# EAST PRESTON PARISH COUNCIL

27<sup>th</sup> April 2020

**Re: EP/37/20/HH, 56 Angmering Lane**

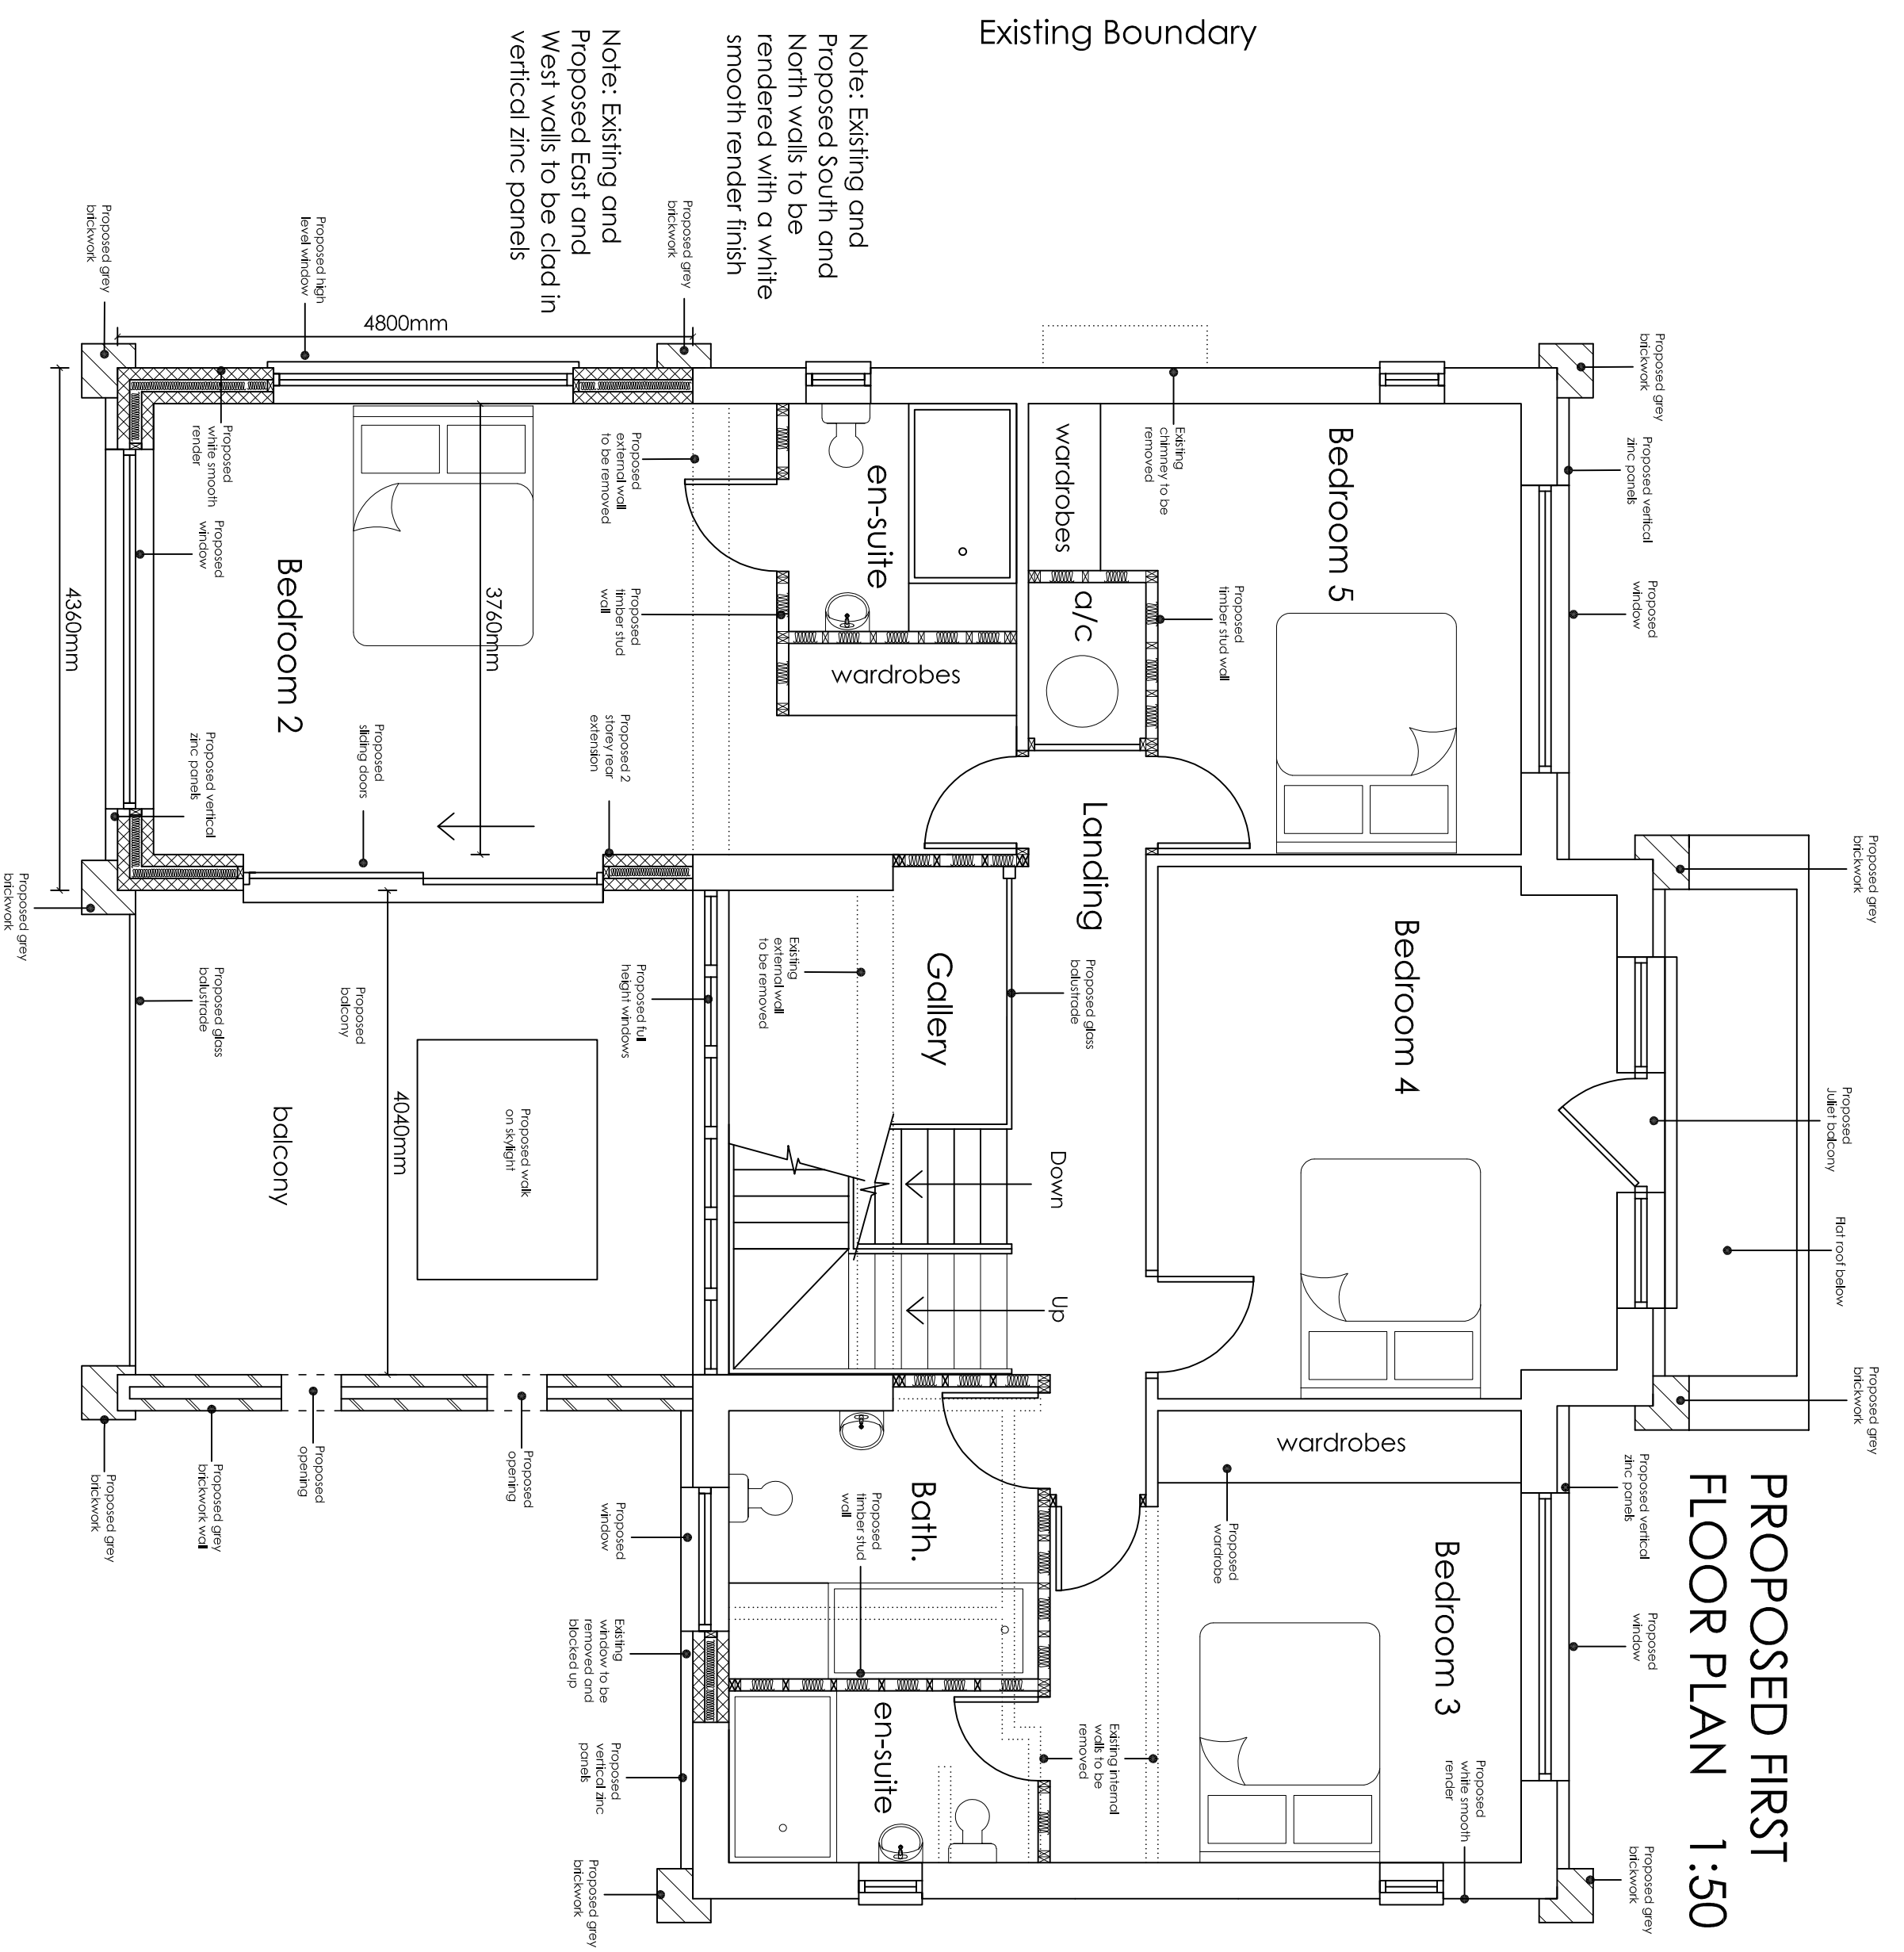
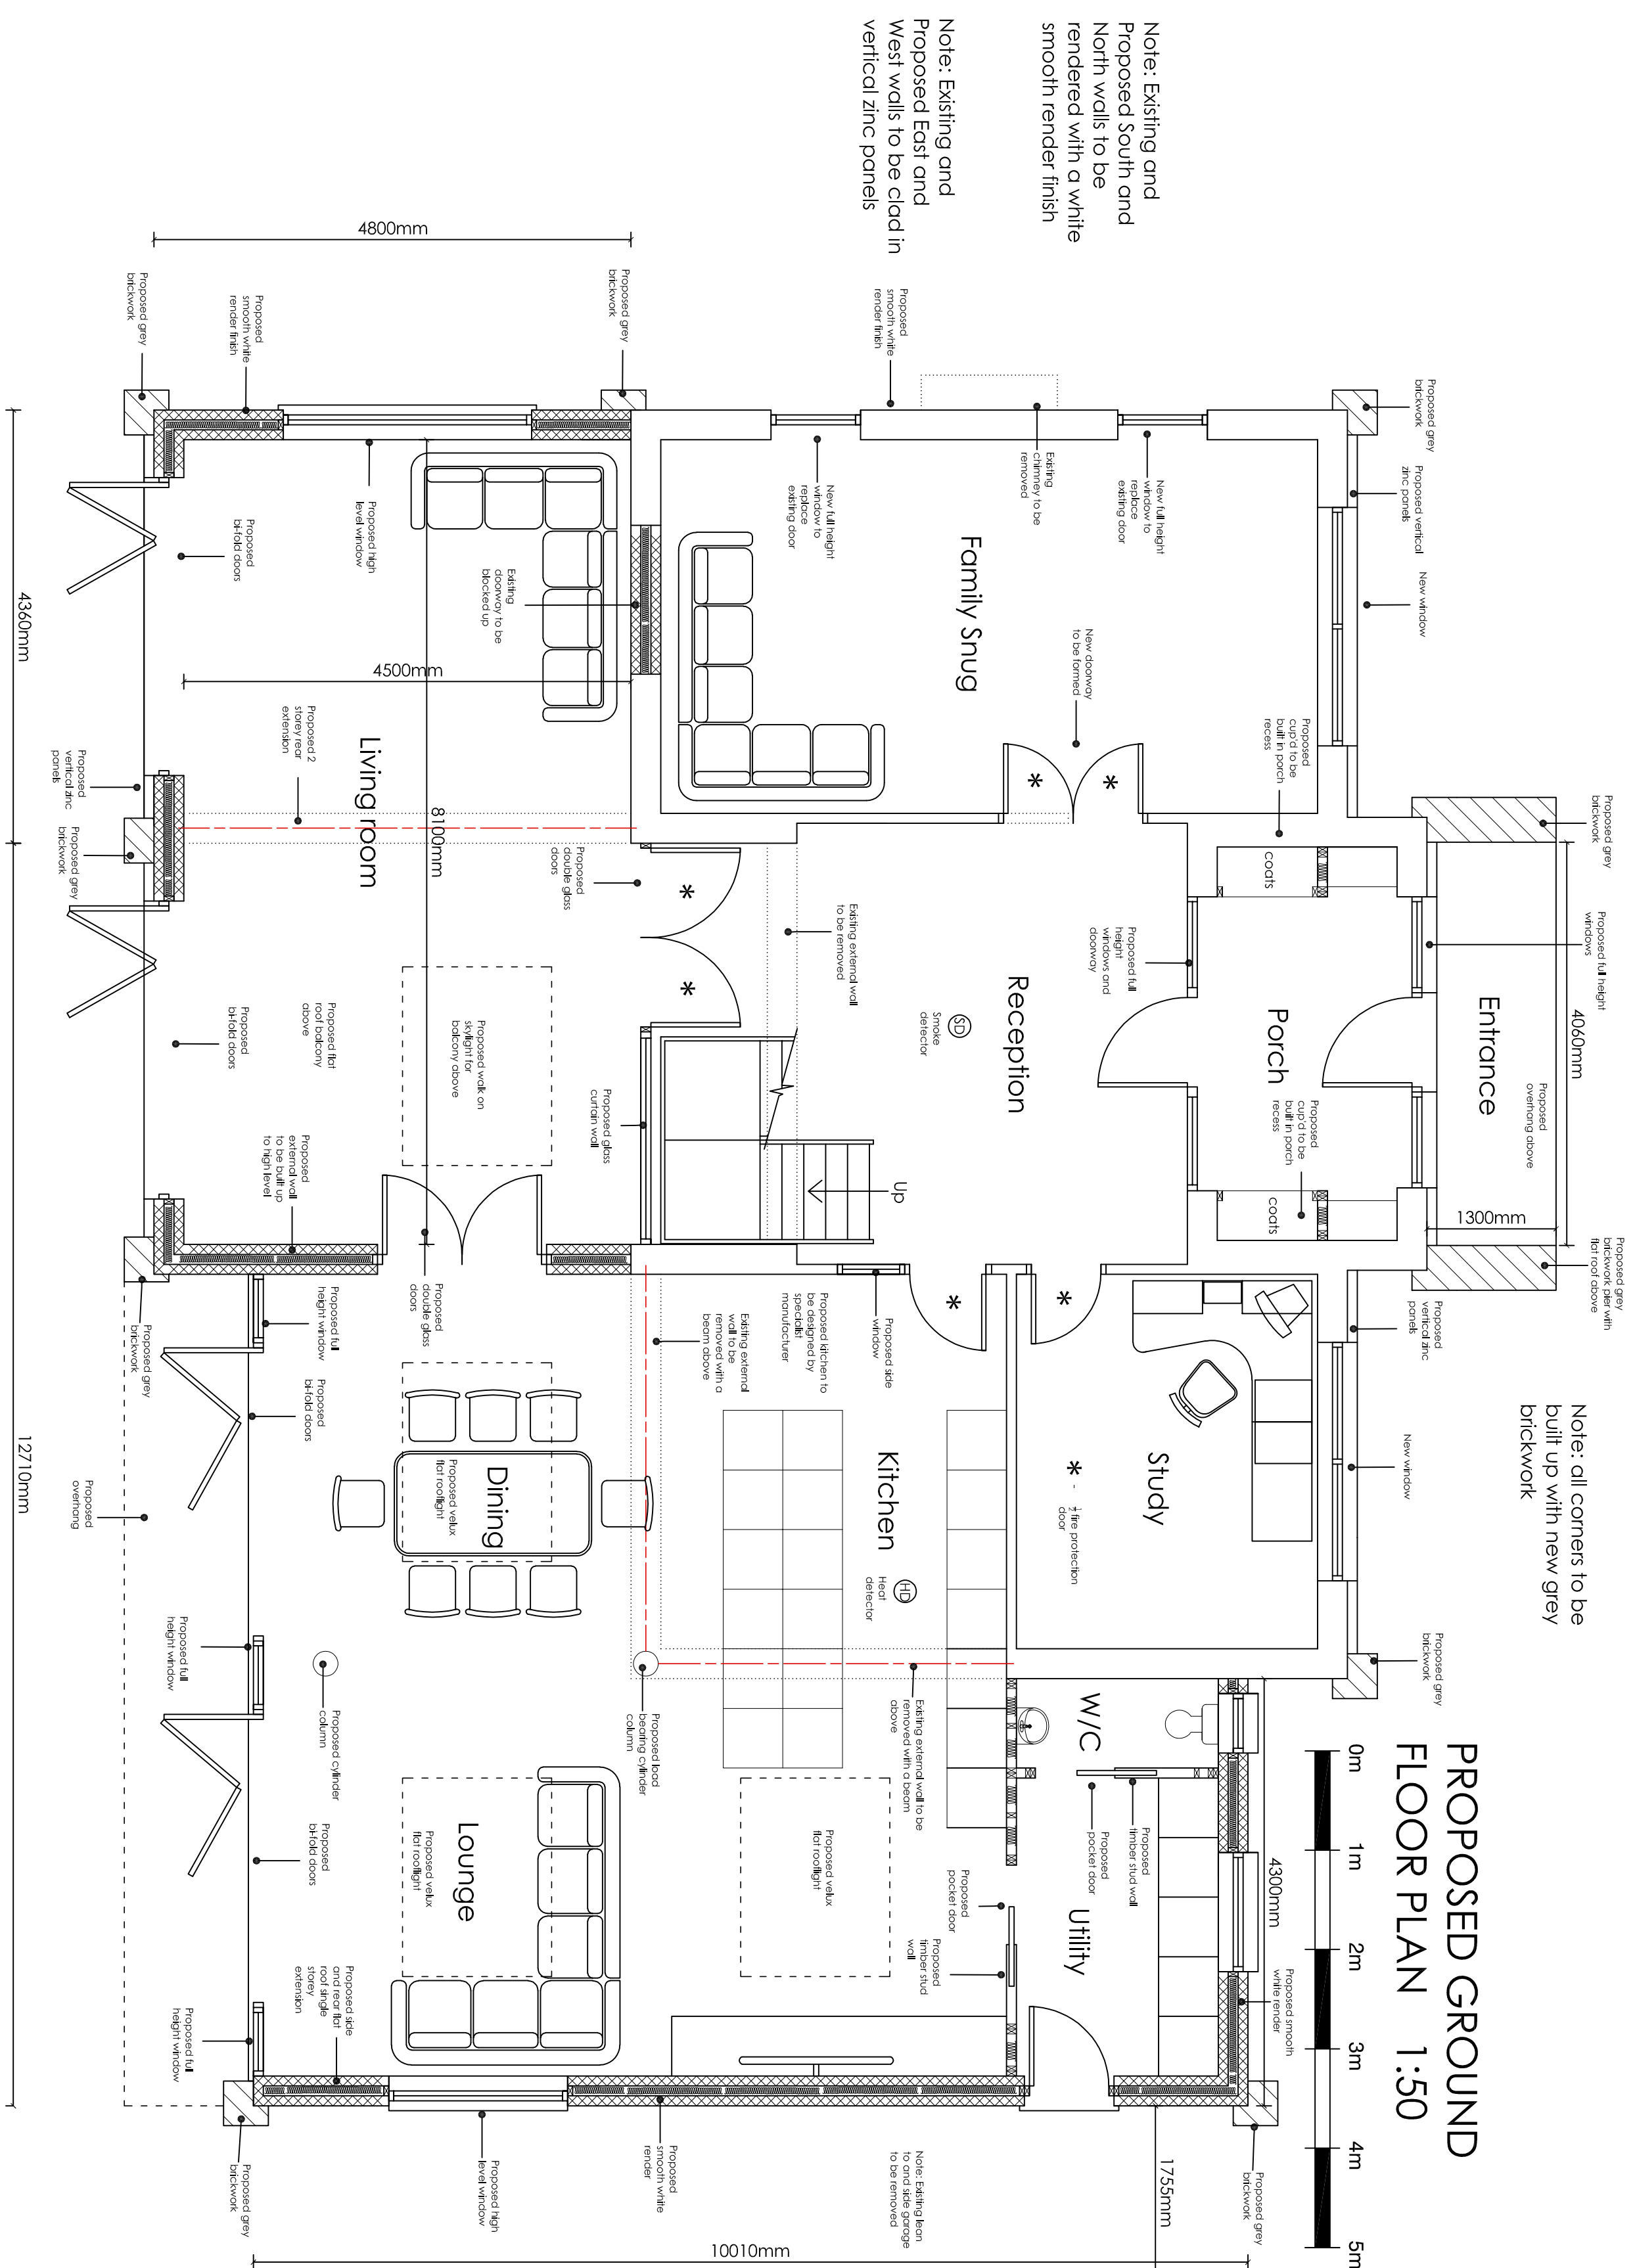
The proposed development is considered to have a significantly harmful impact upon the character of the street scene, and the wider locality, due to its modern appearance, and significant scale. As such, the proposed development conflicts with Policies D DM1 and D DM4 of the Arun Local Plan, and Policies 1 and 2 of the East Preston Neighbourhood Development Plan.

The proposal also conflicts with Policy D DM4 as the does not sympathetically relate to nor is it visually integrated with the existing building in massing, design, form scale and materials. Equally, the extension could not be considered visually subservient to the main building.

The proposed materials are contrary to Paragraph 4.12 which states, "The materials used in new or altered buildings should harmonise in both colour and texture with the materials used in adjoining buildings." Zinc cladding is proposed for the top storey. This council does not believe any other properties on this estate have zinc cladding. Therefore any use of such cladding will leave this property out of keeping with the locality. The same can be said for the proposed use of grey brickwork.

Paragraph 4.14 of the East Preston Neighbourhood Plan states "New or altered buildings that exceed two storeys in height will rarely be acceptable." The proposed redevelopment includes an increase in the height of the property which may appear minimal, but the proposed design of the top storey will result in a property looking much higher without the softening effect of a pitched roof. The resulting property will be out of keeping with the street scene and unneighbourly. The addition of windows in the proposed second storey will directly and unacceptably remove the existing privacy of neighbouring properties. Obscured glazing is proposed for one set of windows on the second floor eastern elevation, presumably to reduce people seeing in, which suggests other windows will be able to see into other properties.

The flat-roofed design of the property is out of character with the rest of the Willowhayne private estate. The existing property is quite visible when approached down Angmering Lane, although it is screened from view directly in front of the property. Because of the increase in mass, the proposed property would have a much greater presence when viewed from further up Angmering Lane, only serving to highlight how out of character the proposed property would be. There is no indication given as to whether the existing screening at the front of the property is to be retained. This could be seen as contrary to Paragraphs 127 and 130 of the National Planning Policy Framework.

The proposed garage is in front of the existing building and is therefore a negative impact upon the spatial character of the area.

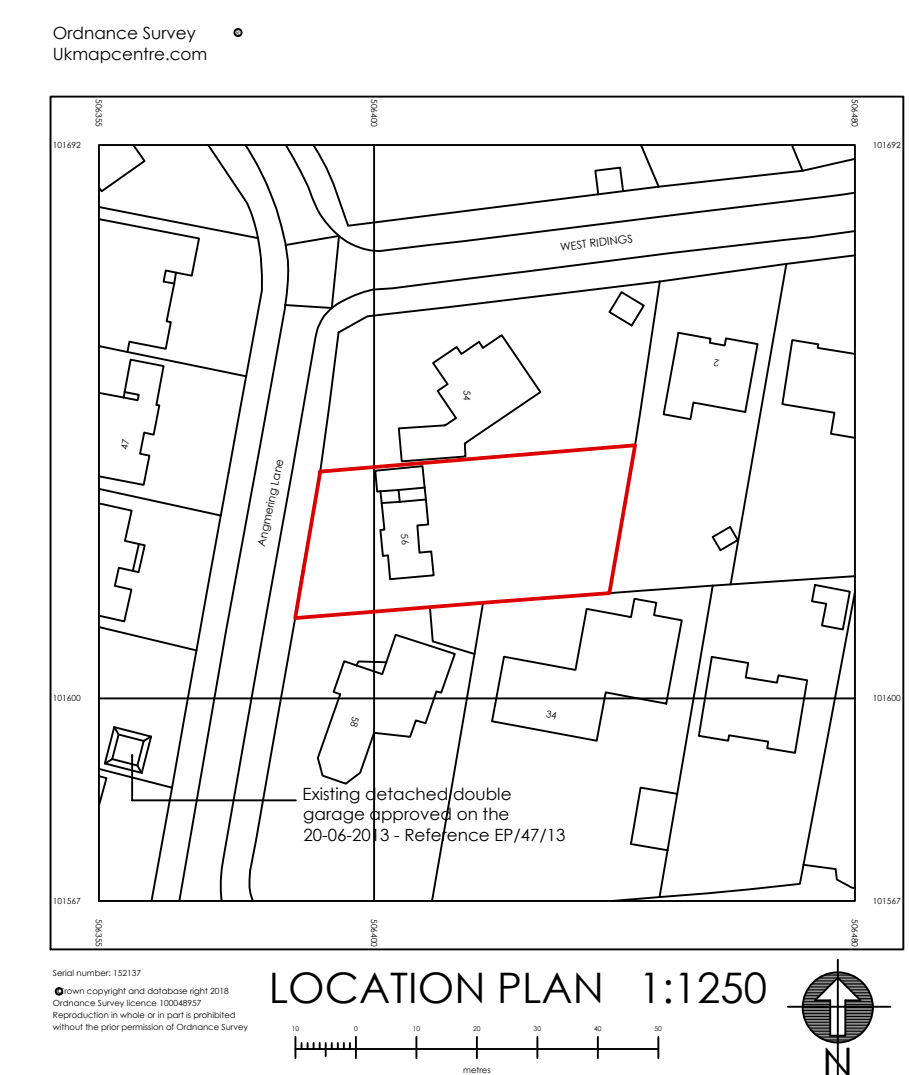
Paragraph 4.16 of the East Preston Neighbourhood Plan states, "Extensions should be designed to look as if they were part of the original design of the house." The proposed redevelopment of 56 Angmering Lane, described as an "extensive refurbishment", does not look part of the original design of the house. It is wholly out of character with the properties surrounding it. Angmering Lane is a mix of architectural styles built up over a number of decades, but all are based in traditional brick and stonework. The proposed build of glass and metal would perhaps be suitable for a site facing the beach, but this is not such a site.
